Location of Construction: 1 Exchange Street		Owner: Joseph L. Soley		Phone: 761-4444		Permit No:	
Owner Address:		Lessee/Buyer's Name:		Phone:		Business Name:	
Contractor Name: USA Maintenance, Inc.		Address: Shapliegh, ME		Phone: 329-3201		Permit Issued:	
Past Use: Commercial		Proposed Use: Commercial		COST OF WORK: \$ 0.		PERMIT FEE: \$ 30.00	
				FIRE DEPT. <input checked="" type="checkbox"/> Approved <input type="checkbox"/> Denied		INSPECTION: Use Group A-3 Type <i>3B</i> <i>BOCA 99</i>	
Proposed Project Description: Bar with wall		Signature: <i>[Signature]</i>		Signature: <i>[Signature]</i>		Zone: <i>B3</i> CBL: 032-F-014	
		PEDESTRIAN ACTIVITIES DISTRICT (P.A.D.)		Action: Approved <input type="checkbox"/> Approved with Conditions: <input type="checkbox"/> Denied: <input type="checkbox"/>		Zoning Approval: <i>OK with conditions</i>	
Permit Taken By: Gayle		Date Applied For: December 15, 2000		Gg		Special Zone or Reviews: <input type="checkbox"/> Shoreland <input type="checkbox"/> Wetland <input type="checkbox"/> Flood Zone <input type="checkbox"/> Subdivision <input type="checkbox"/> Site Plan maj <input type="checkbox"/> minor <input type="checkbox"/> mm <input type="checkbo

HEADROOM DETAIL.  
 #1 EXCHANGE ST  
 THE BASEMENT.  
 Red = Sam

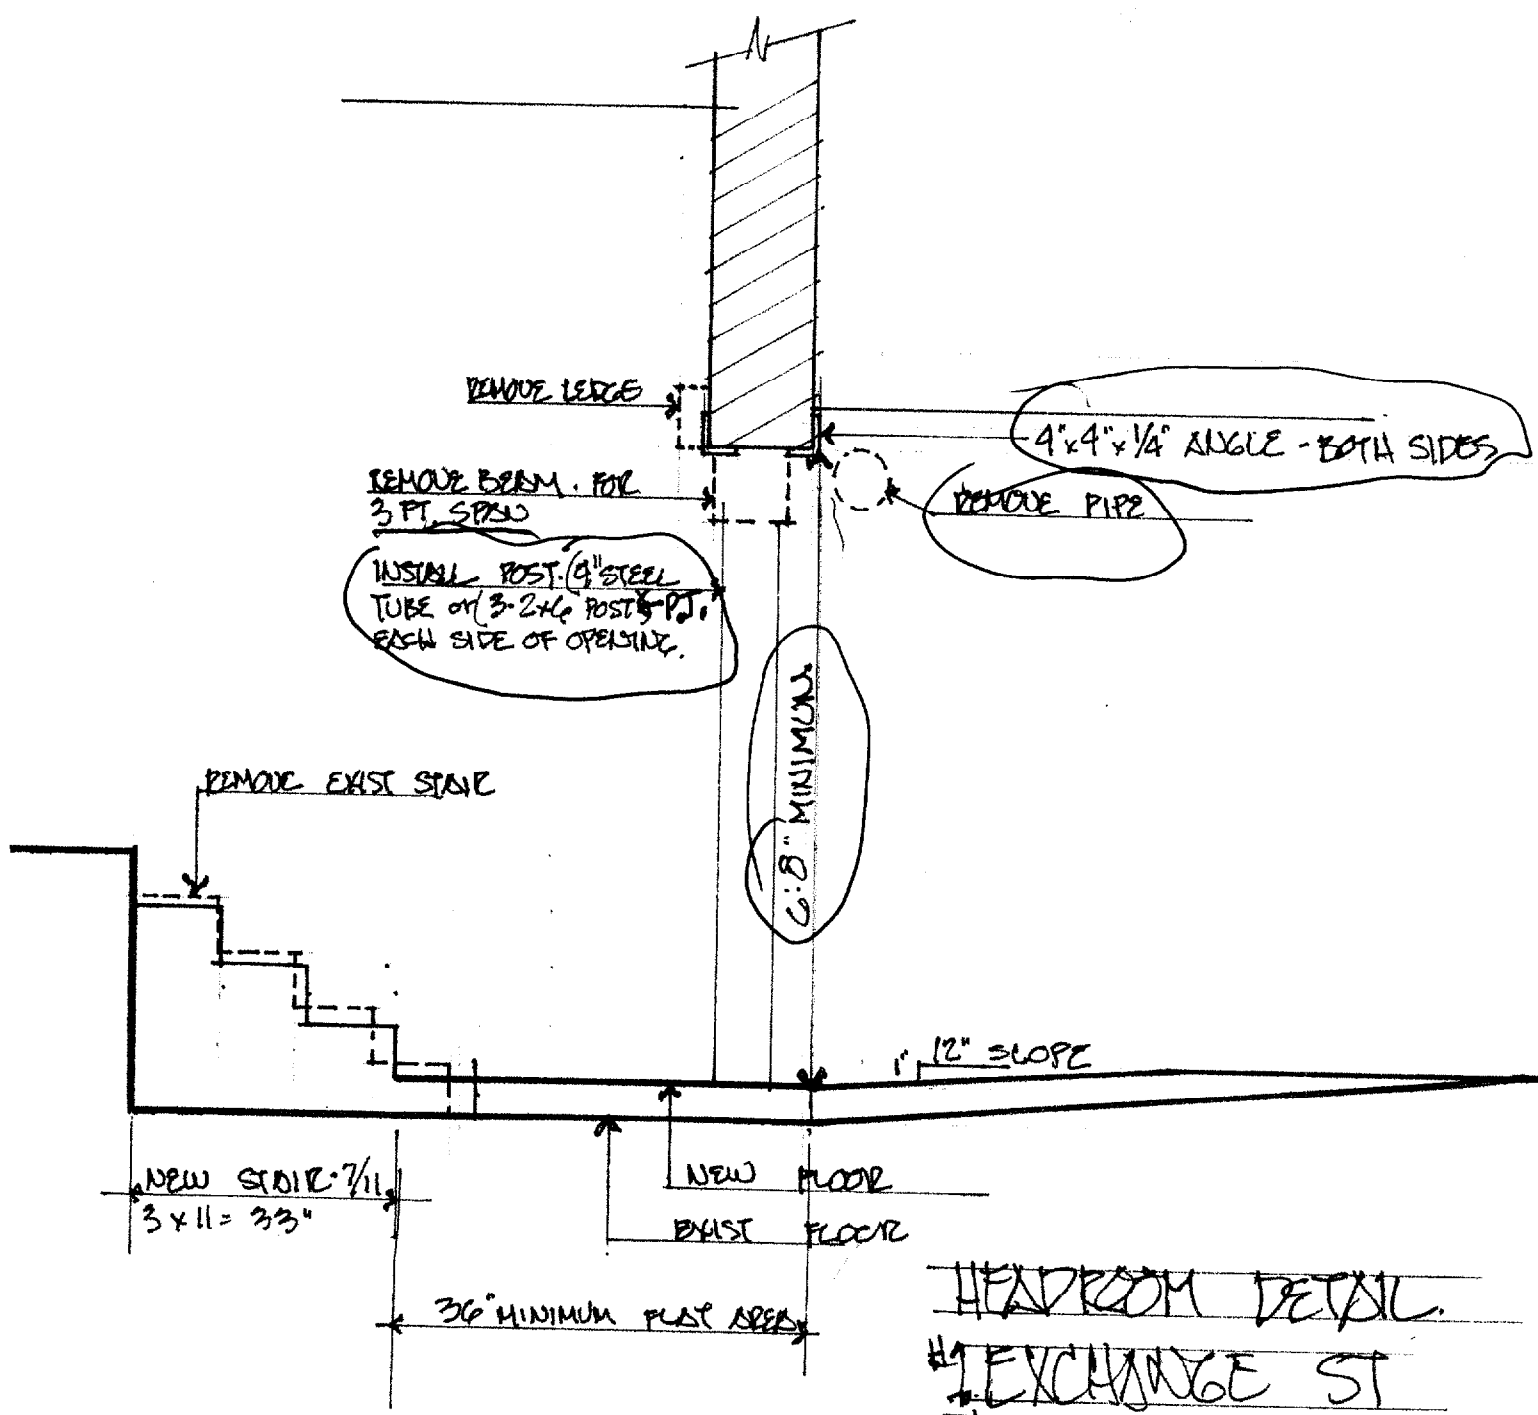
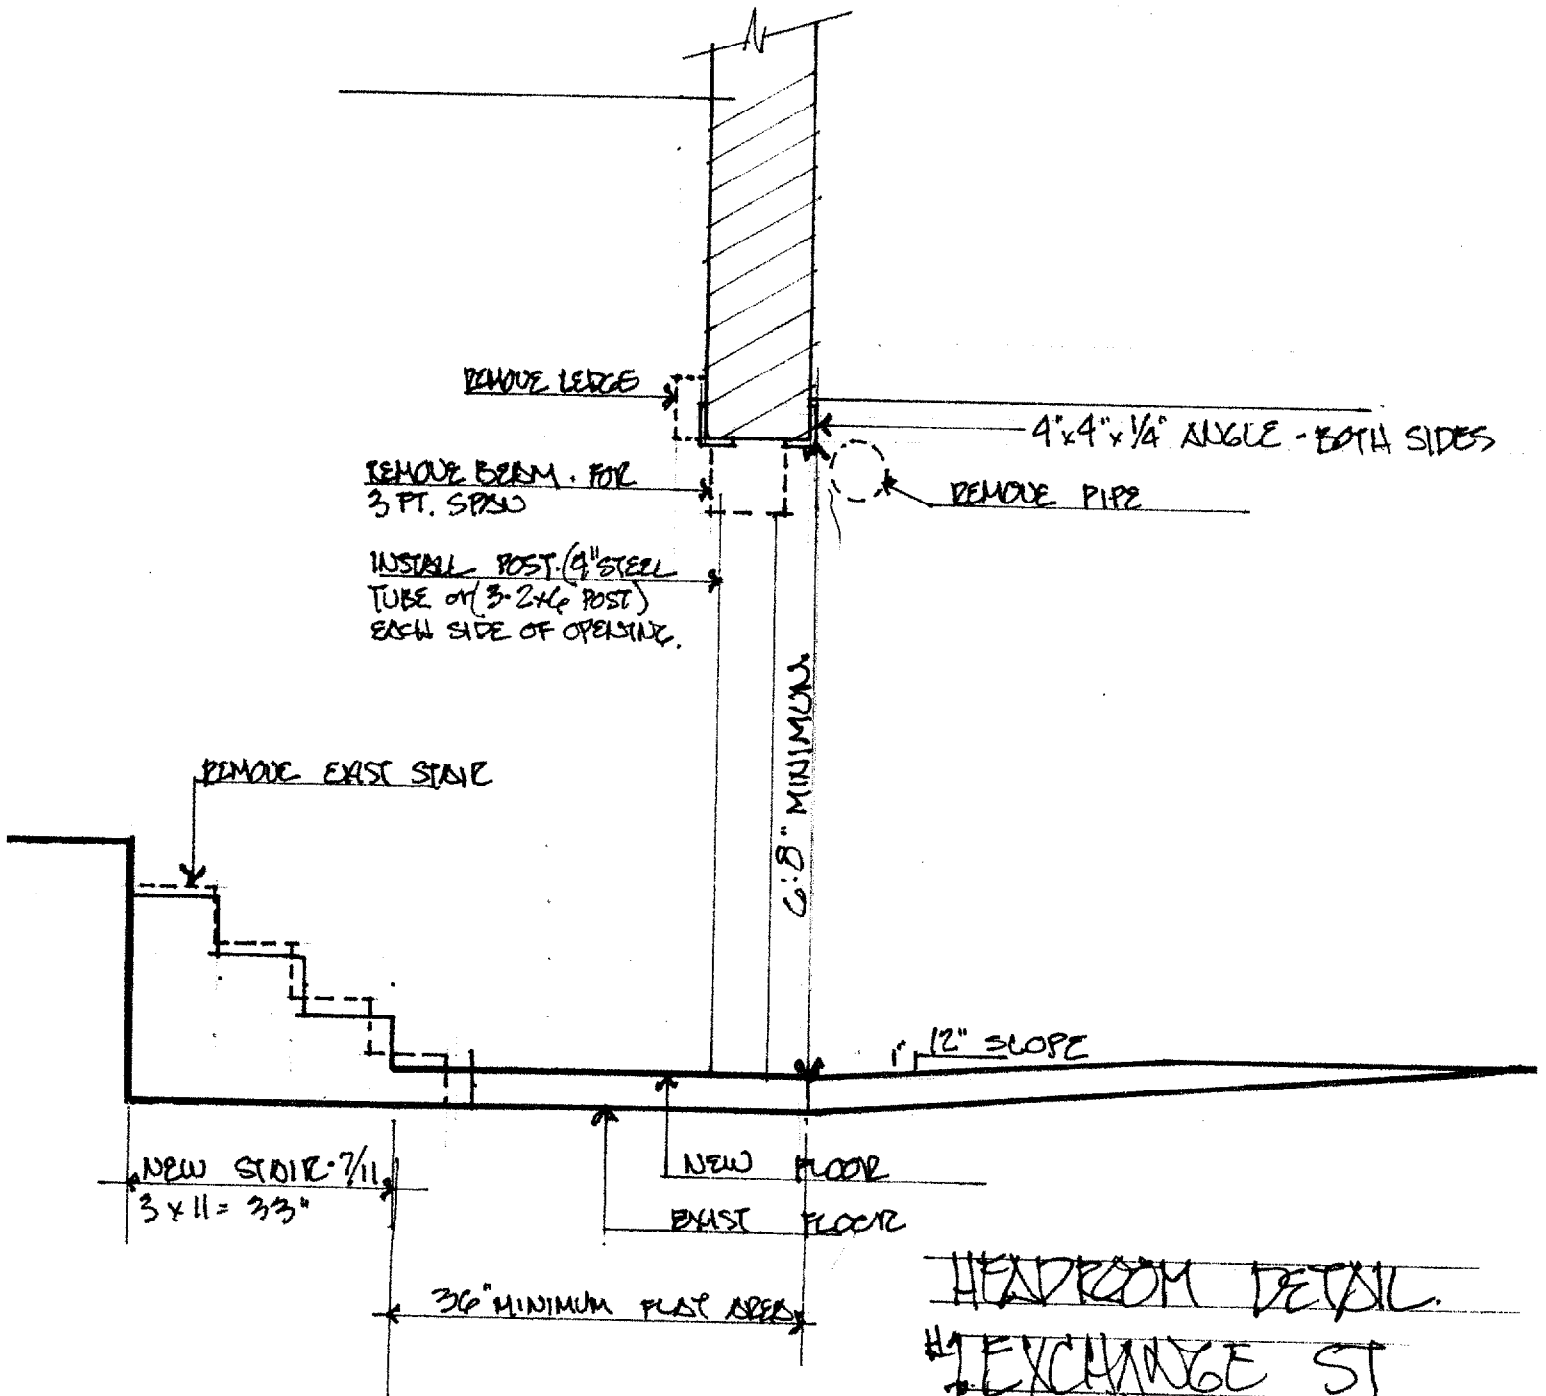
*38. The opening in the room with stairs shall be a minimum of 48" STAIRS / 7" 11" with handrails both sides.
